LU/49/18/Doc Condition 4

Response from ADC Drainage to LU/49/18/DOC - Kingley Gate

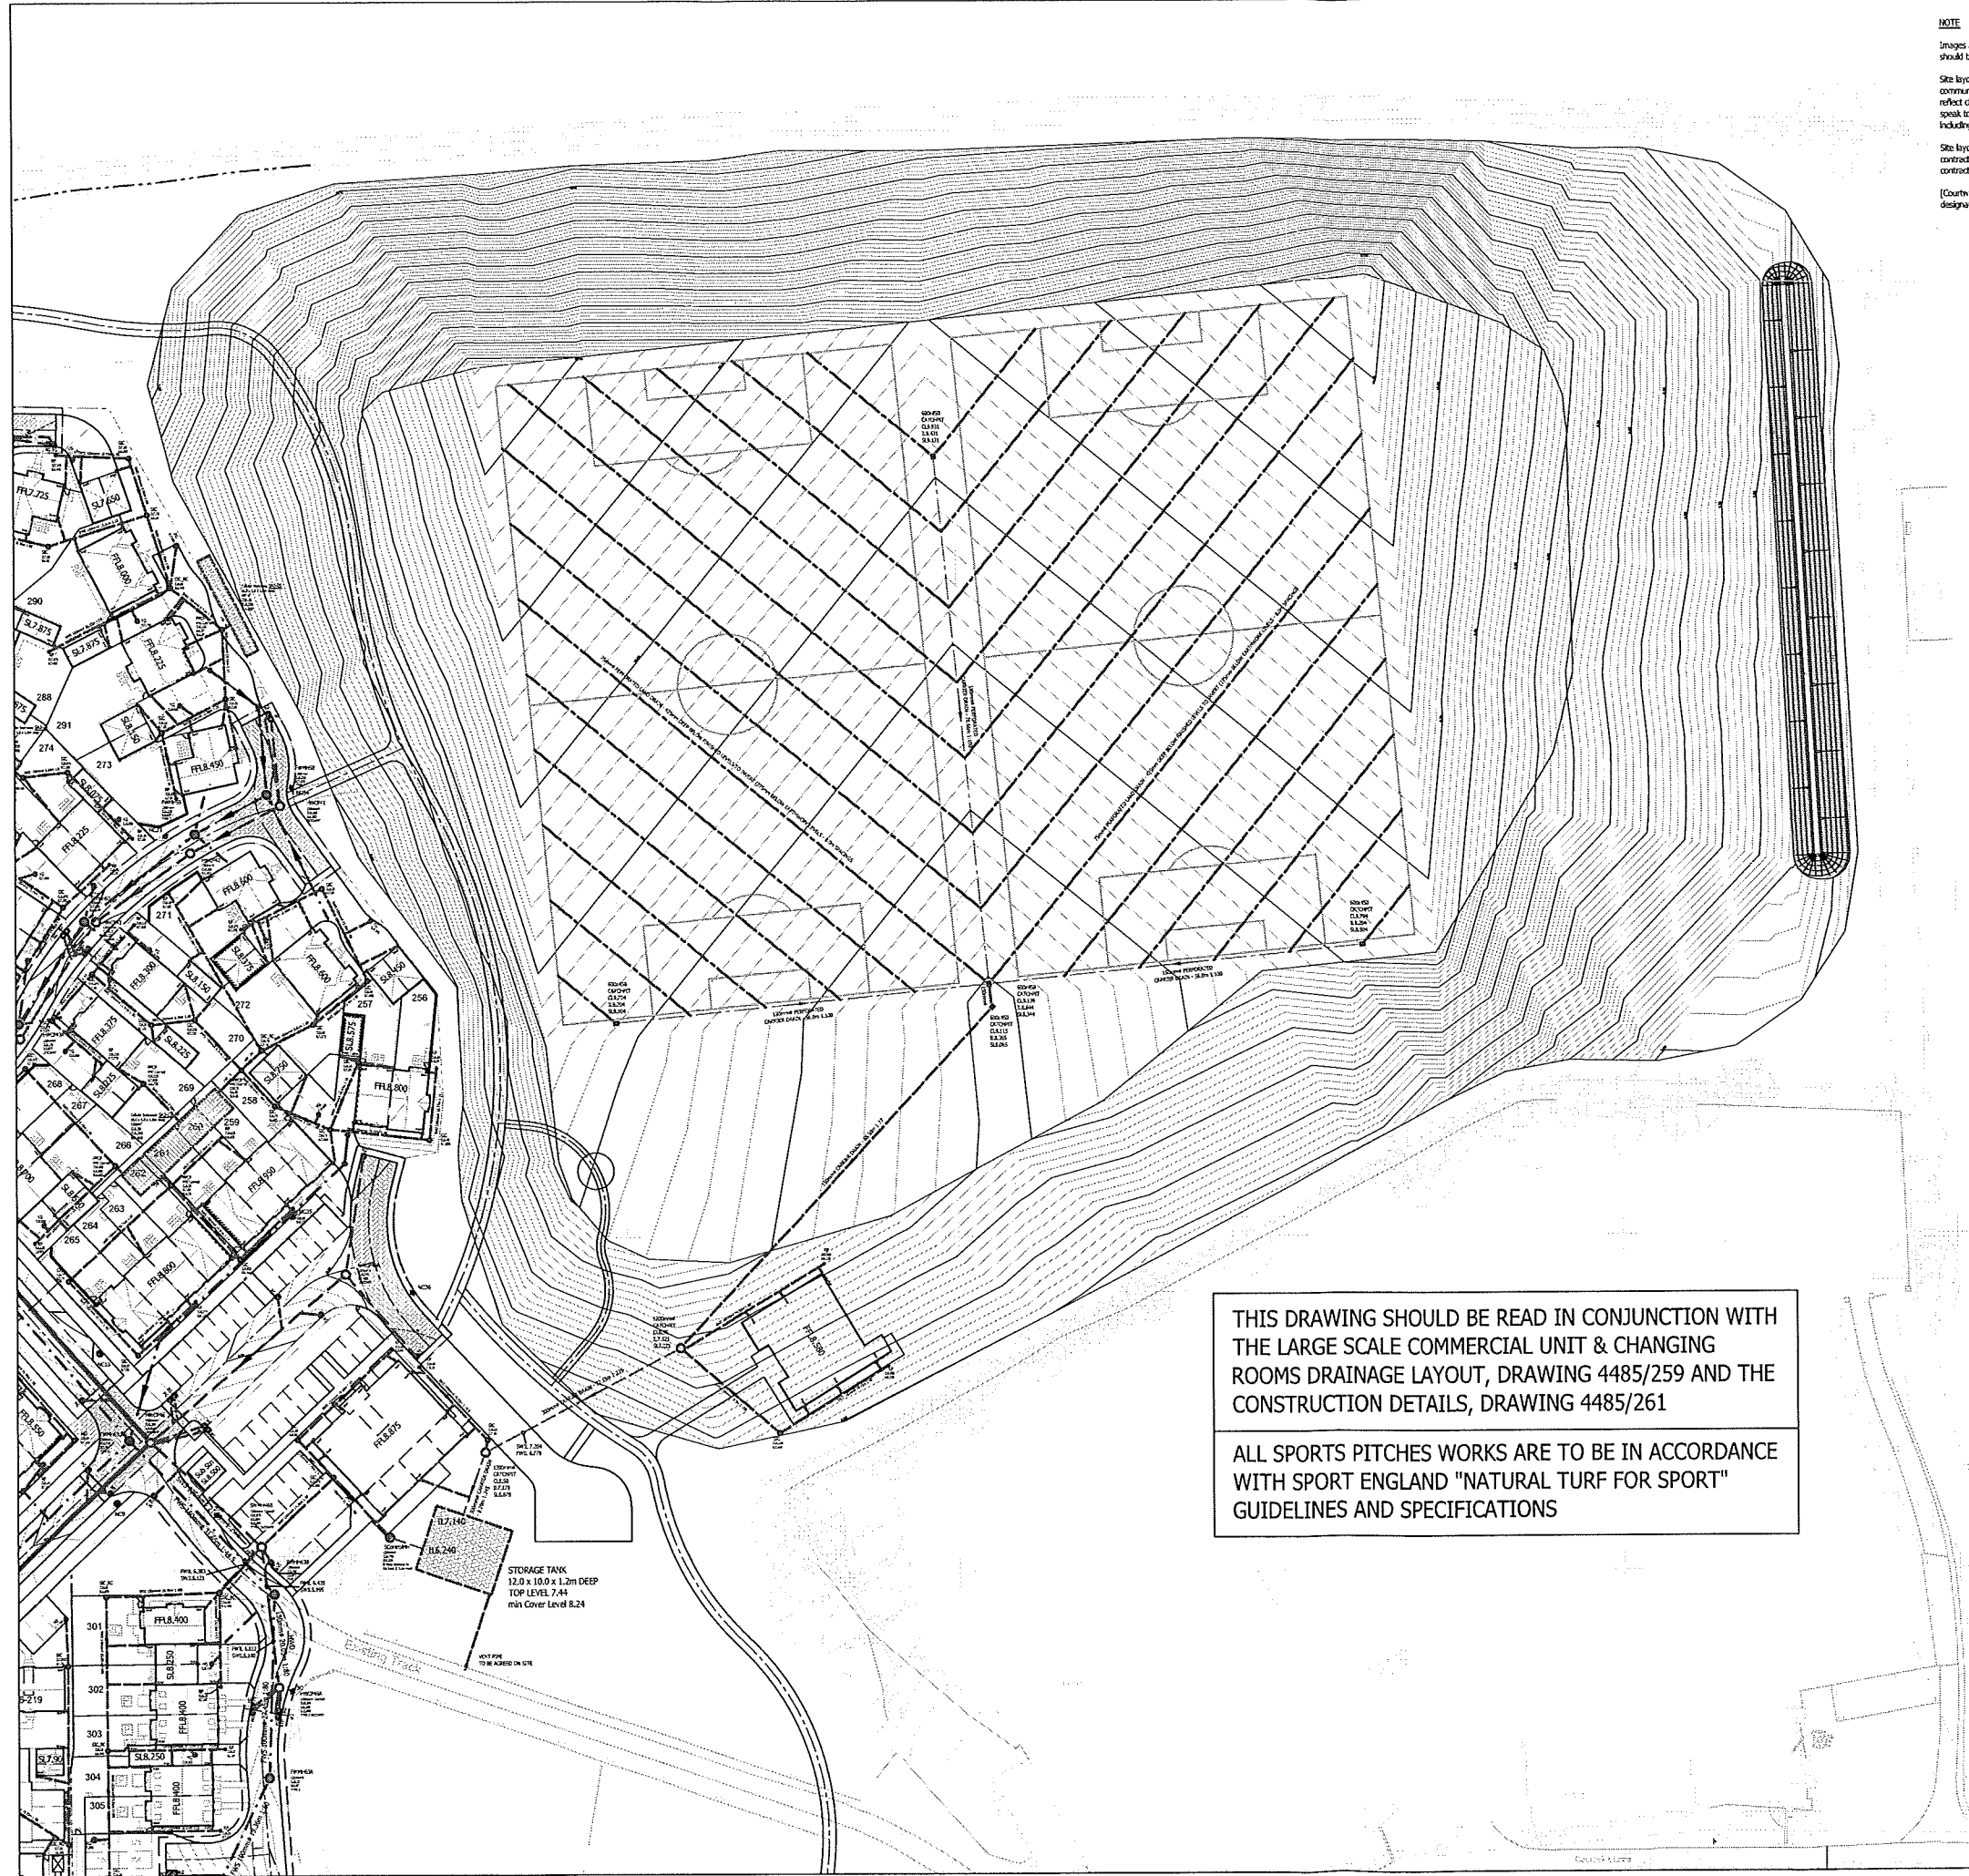
I have reviewed the supplied information. Land drains have been specified directly under the sports pitches. However, there is nothing to control the run off of water down the slopes from the raised pitches, and to prevent it from discharging on to neighbouring land. There is also no method of intercepting the surface water run-off from entering the sports pavilion. Therefore, my previous comments still apply:

Drainage from the site needs to be controlled to ensure no detriment is caused to surrounding land and properties. Currently the plans show no way of controlling run off from the site. We recommend this is reviewed, and drainage is included around the perimeter and that the proposed changing facilities also have drainage around them to ensure that surface water does not flow off of the pitches and through them.

As requested, please find attached drawing 4485_257E which shows the proposed finished floor levels of the mixed use building and changing rooms along with our proposed drainage strategy for the run-off of the sports pitches. As mentioned we have appointed a company called Turfdry to provide detailed design, advice and expertise on the delivery of the sports pitches to Sports England specification, this may impact of the drainage strategy for the pitches but we will advise in due course.
